ROADWAY AND STORM SEWER CONSTRUCTION PLANS  
FALCON MEADOWS AT BENT GRASS FILING NO. 3  
FALCON, CO 80831 - EL PASO COUNTY  
CHALLENGER COMMUNITIES, LLC

FUDSP-20-005 (FALCON MEADOWS AT BENT GRASS PRELIMINARY PLAN)  
SF-22-16 (FALCON MEADOWS AT BENT GRASS FILING NO. 3)

# Construction Drawings\_v2 redlines.pdf Markup Summary 7-25-2022

SOPHIA LANE (STREET D)
STA: 4+18 - 6+97.76 SCALE: H: 1"=30' V: 1"=3'

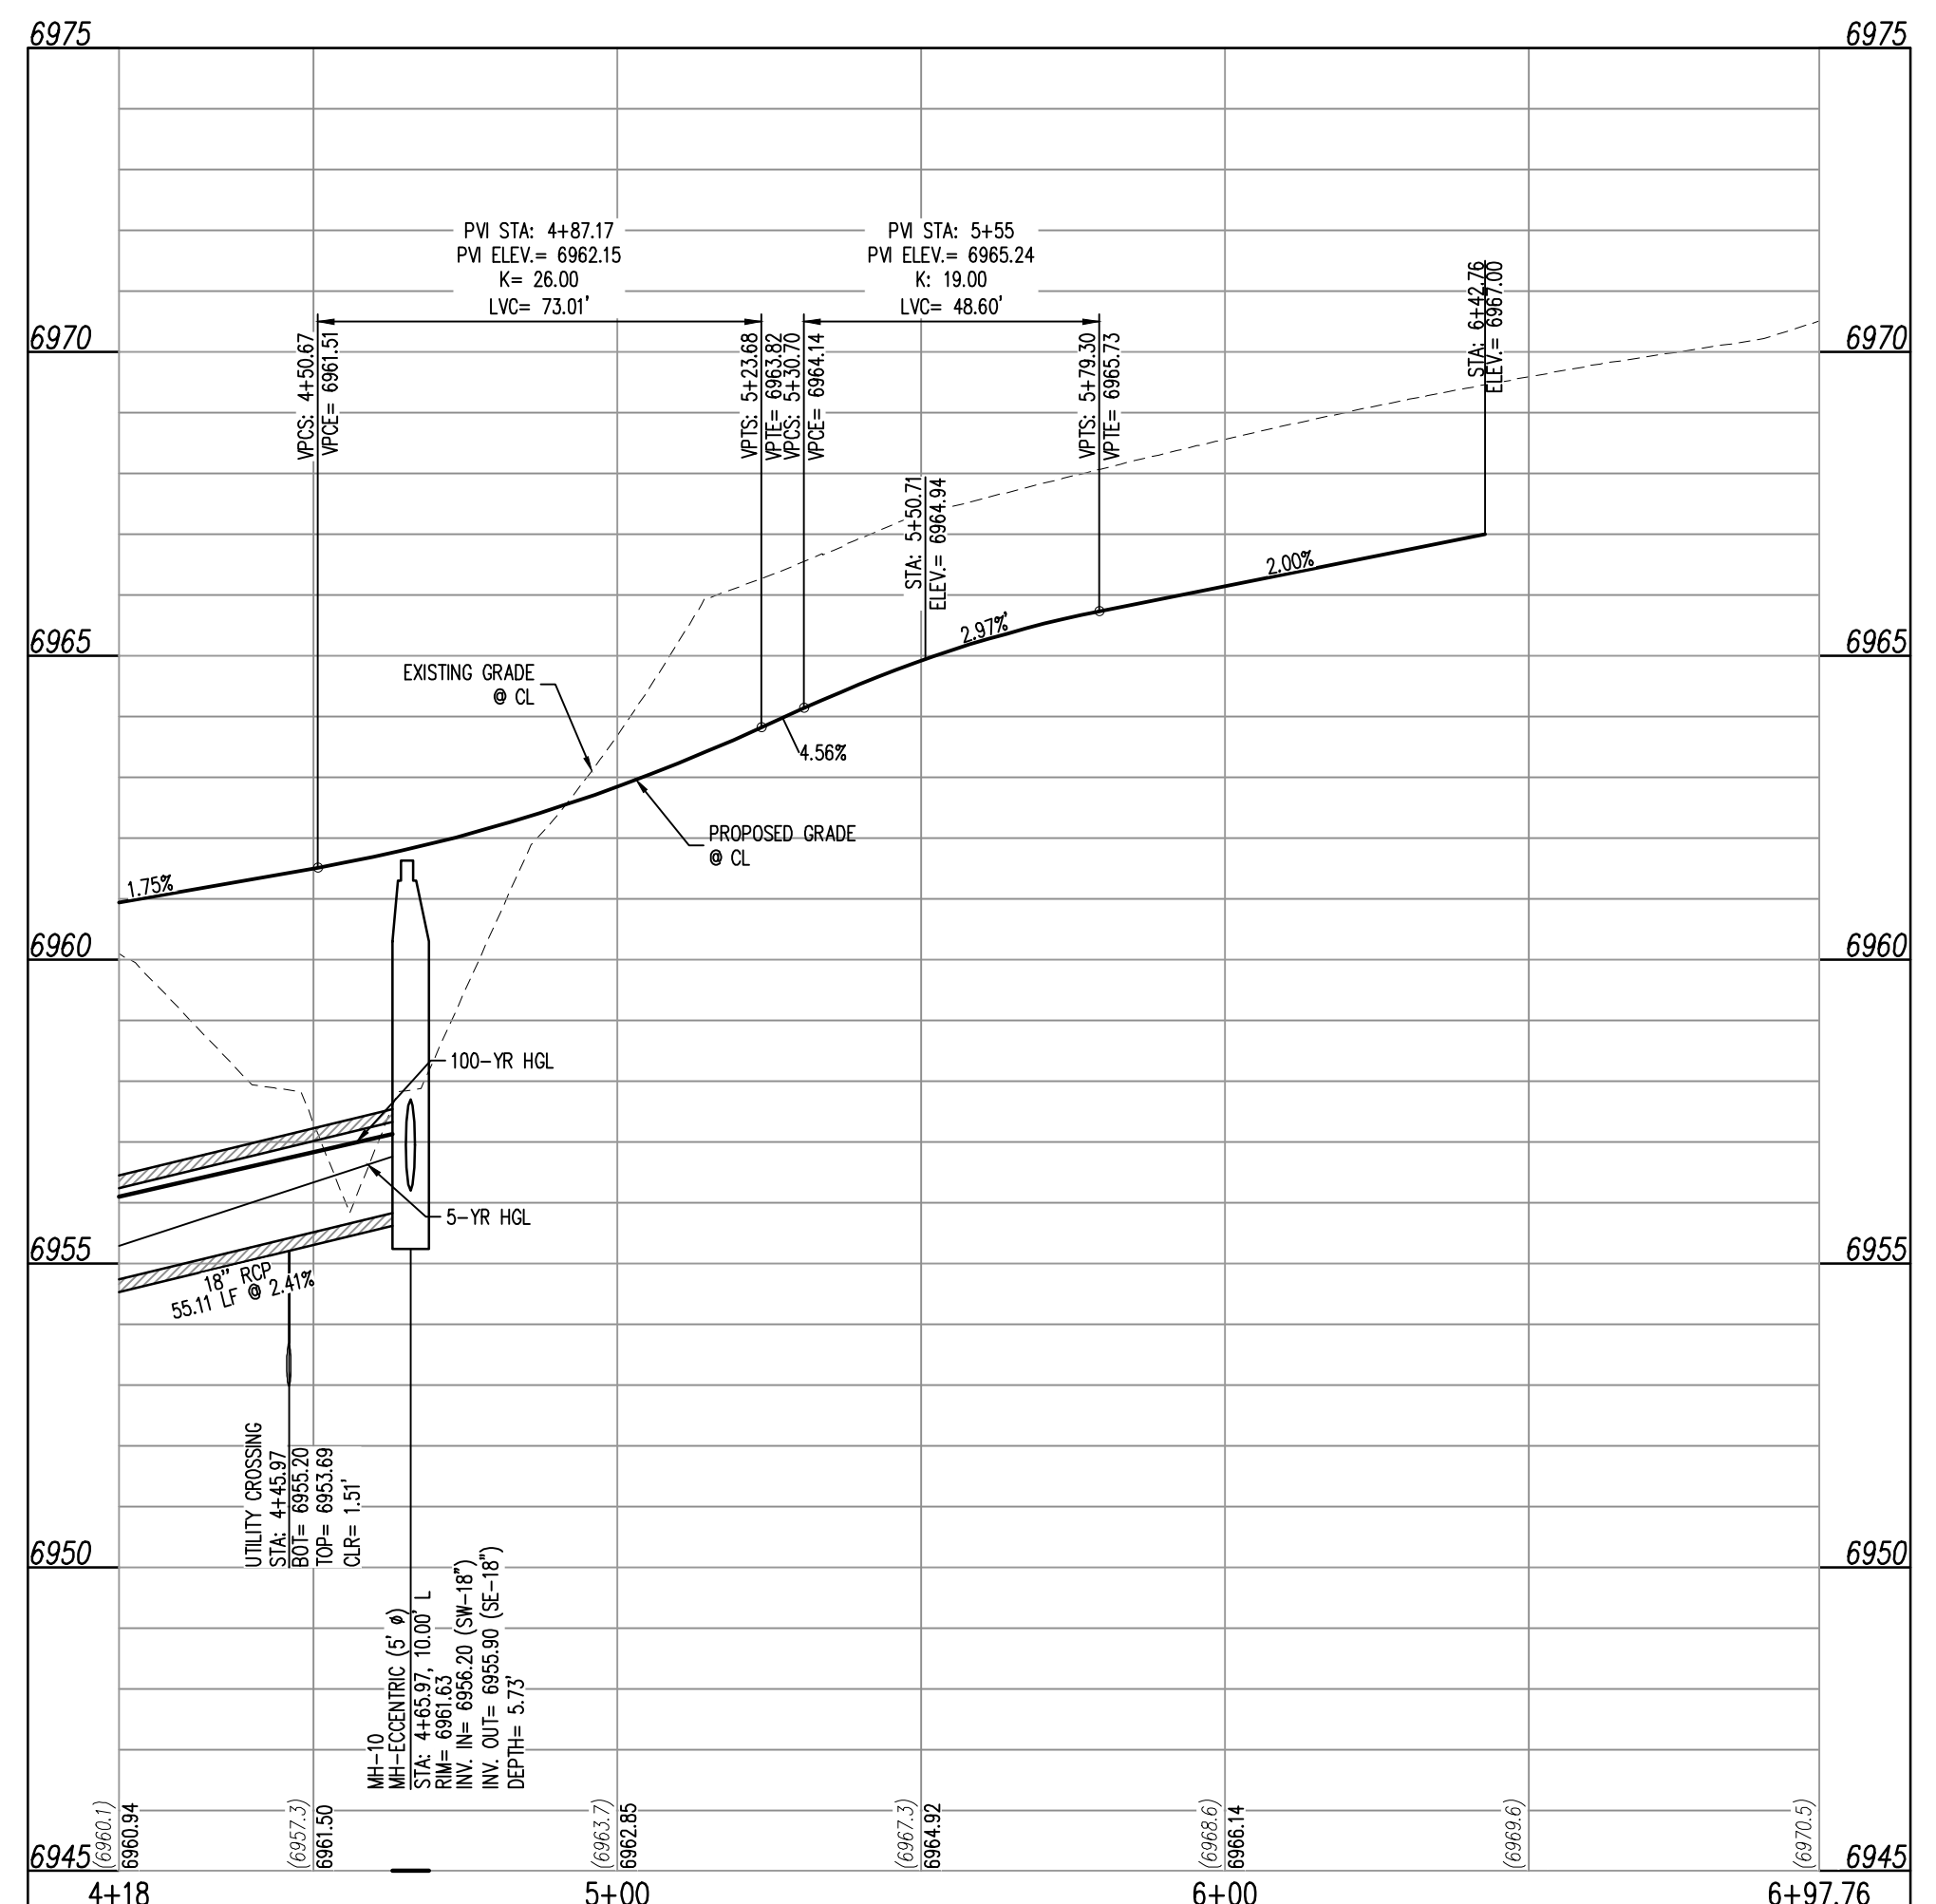
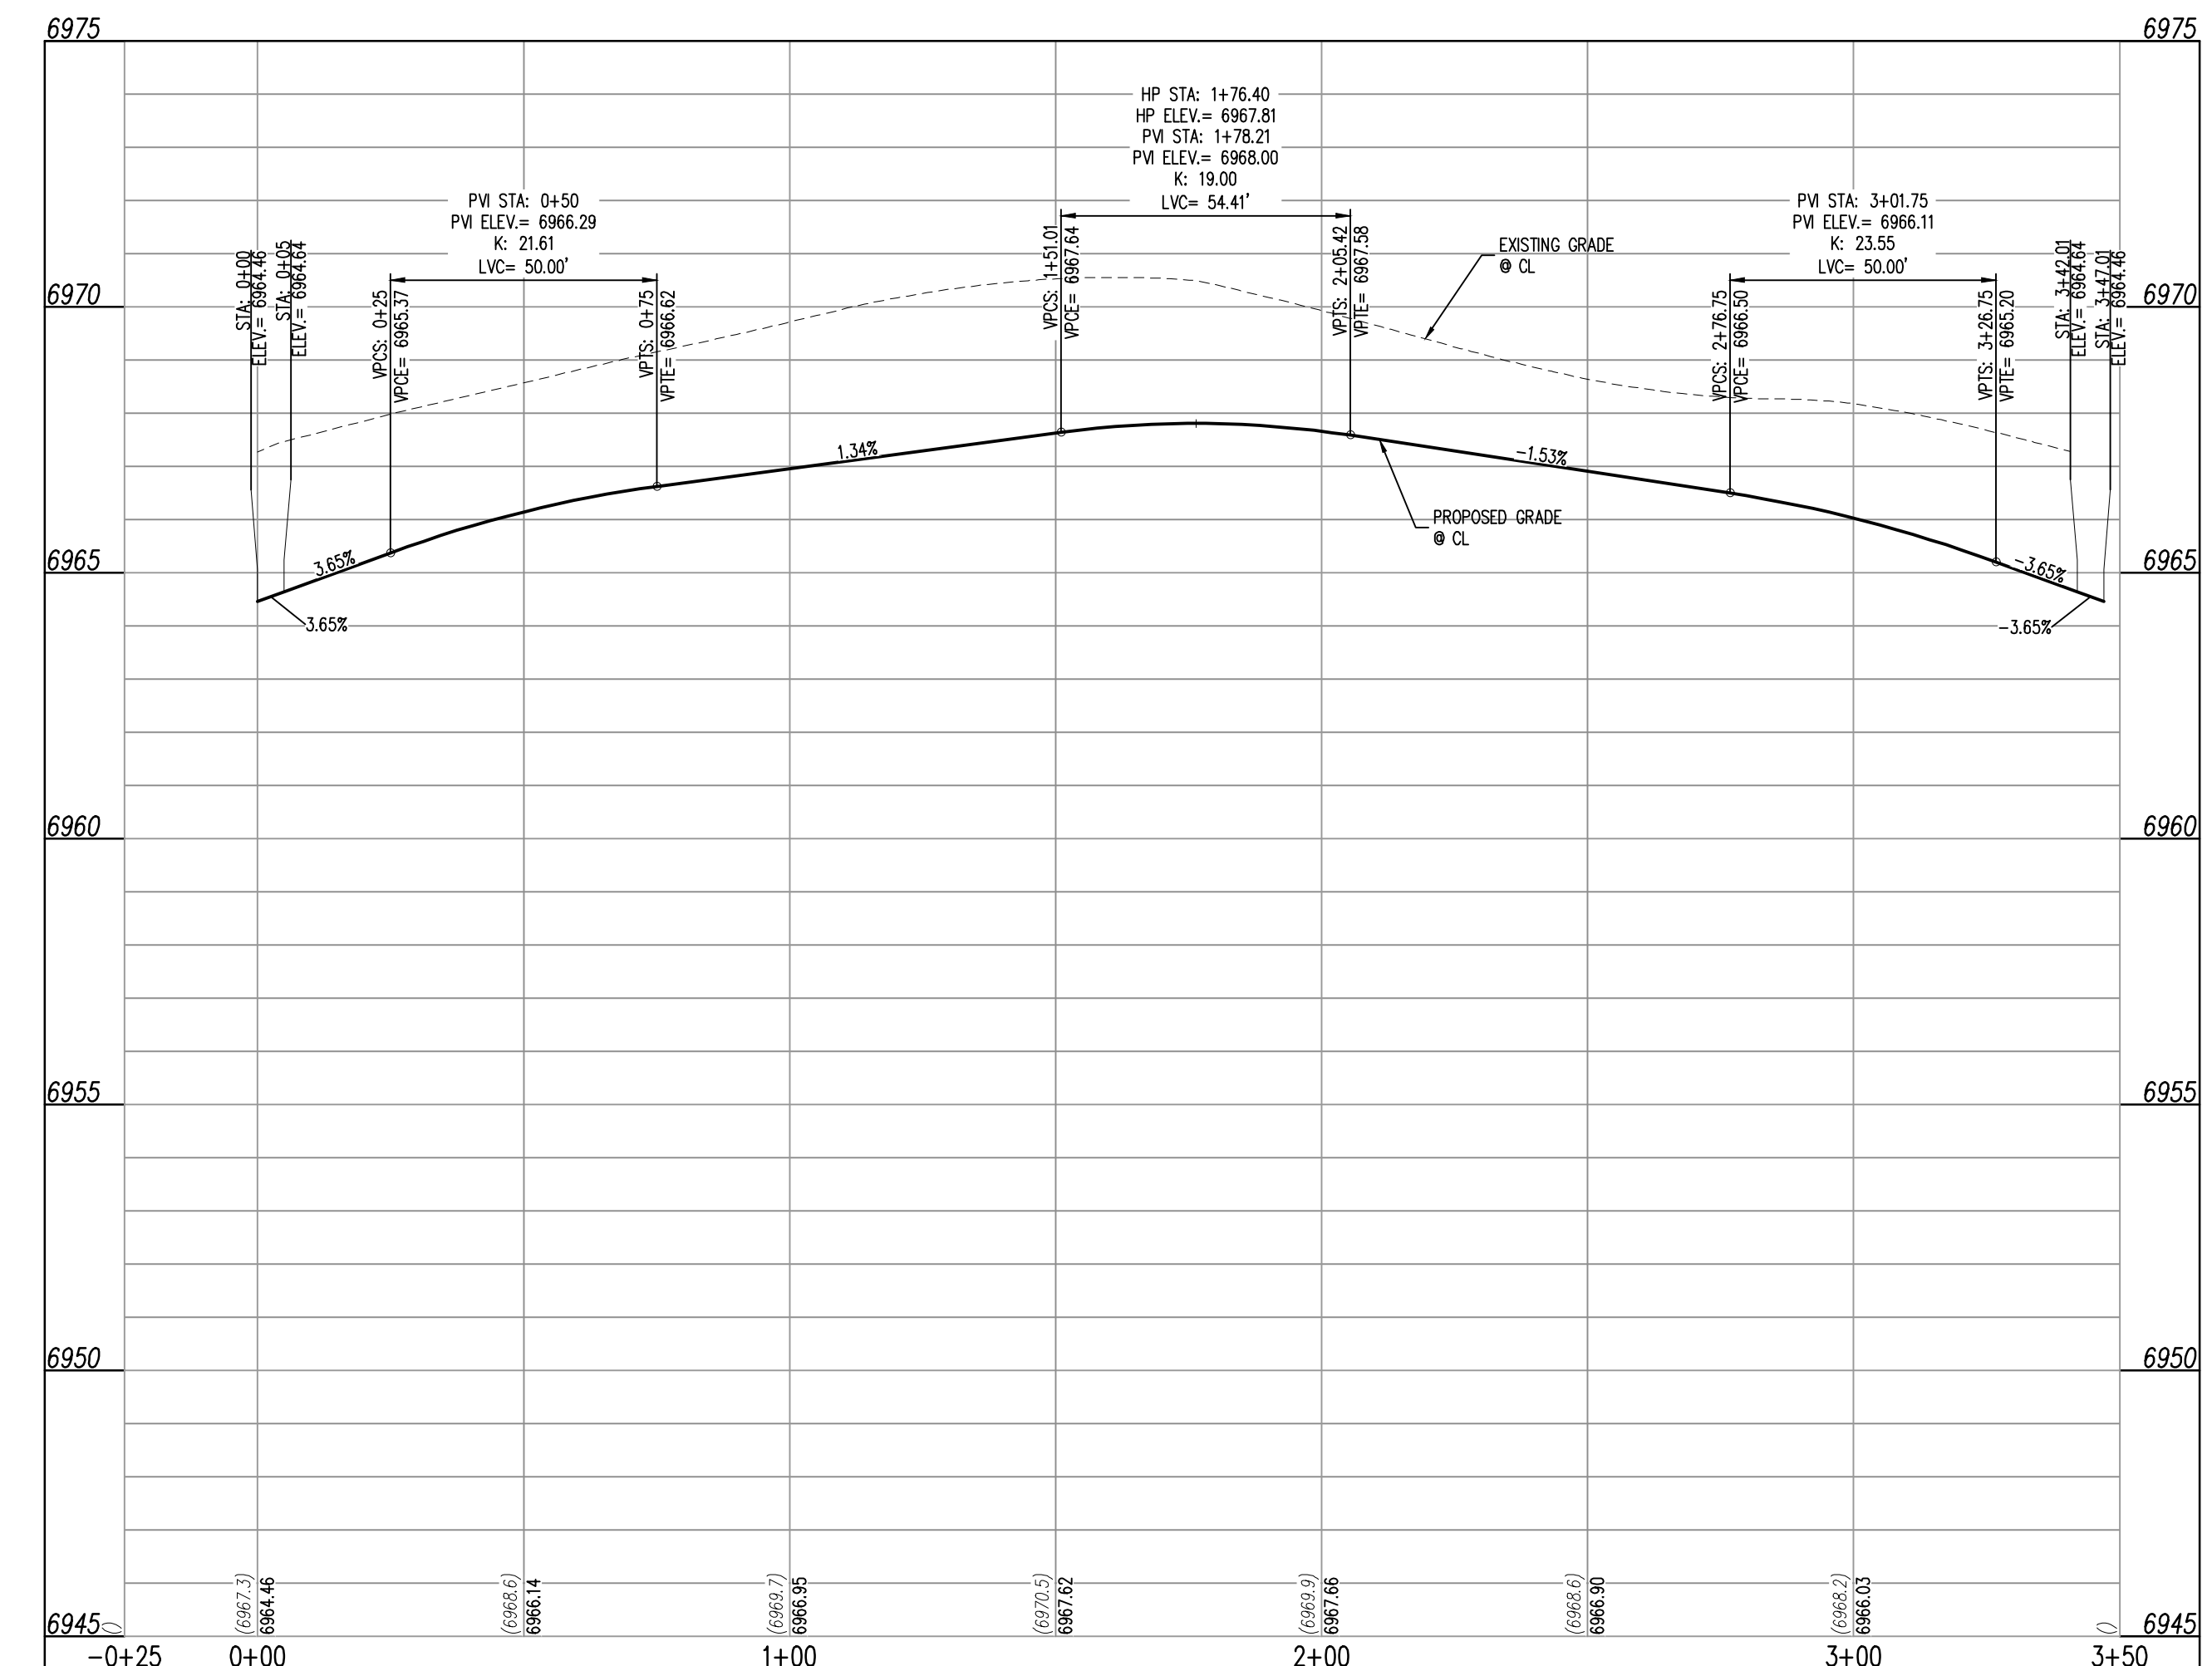
It appears that the indicated slope shown on the profile does not match the revised plan above. Please revise accordingly such that the 3% max slope is complied with.
